Cc: Kate Giddings <kate.giddings@arun.gov.uk>; Nina Sidhu <Nina.Sidhu@arun.gov.uk>; Juan Baeza <Juan.Baeza@arun.gov.uk>
Subject: FW: Sounds testing and noise of plant

From: Kate Giddings <kate.giddings@arun.gov.uk>
Sent: 04 December 2019 17:29
To: Zac Denton <Zac.Denton@arun.gov.uk>
Cc: Planning.Responses <Planning.Responses@arun.gov.uk>
Subject: EP/100/19/DOC - 23 Sea Road, East Preston, BN16

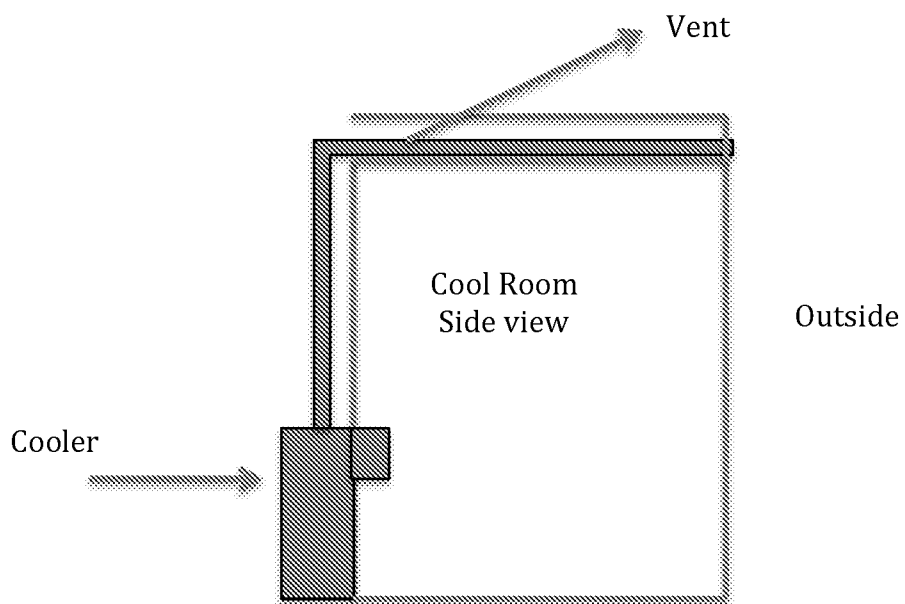
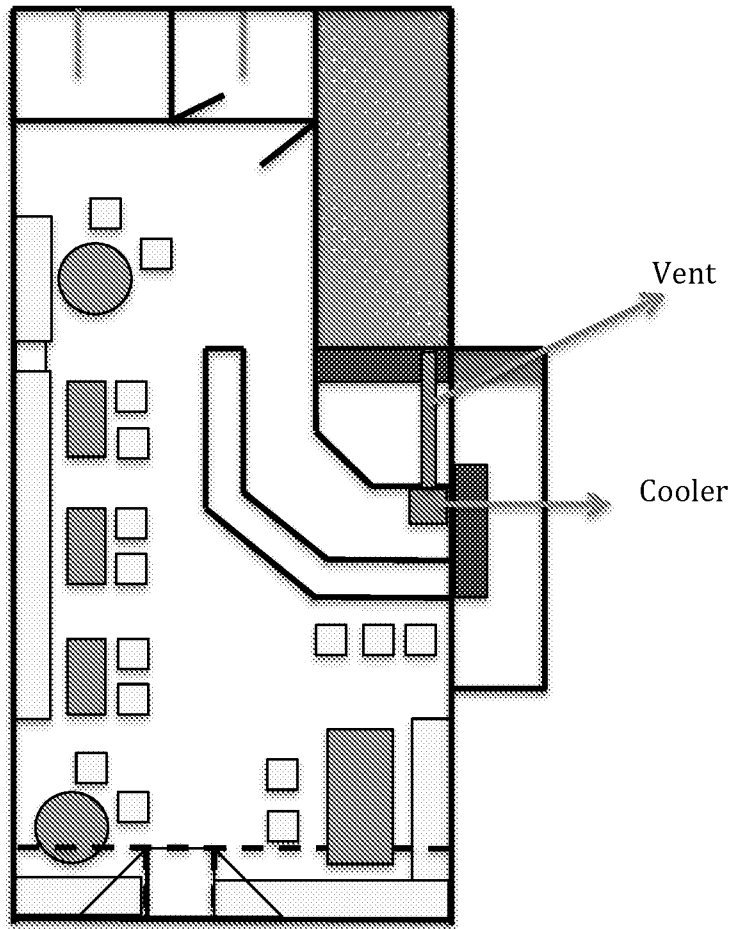
The information supplied by the applicant is helpful, however, in order to be able to consider discharging the condition, the following points need to be addressed:

- *what is the distance between the cooler and the termination point of the ducting?
- *what material(s) is/are being used for the ducting?
- *how will vibration from the plant and associated ducting be managed?
- *at what height does the ducting terminate?
- *how far is the termination point from the nearest noise sensitive receptor?
- *when will the cooler/ducting be in operation (for example, when the premises is open/when the temperature rises above a certain threshold/all the time)?

The distance from cooler to ducting termination is approx 2.5m.

Plastic ducting held in place with fastening clips and boxed in to top of cool room below new lowered, soundproofed ceiling.

Anti vibration pads for plant and anti vibration clips for ducting.

Ducting terminates at approx 2.4m off FFL

Extraction outlet will be approx 1.5m bellow the upstairs window, However, there will be no plant on the external or internal wall, as it will only be a vent as the cooler unit will blow the air through the ducting directly.
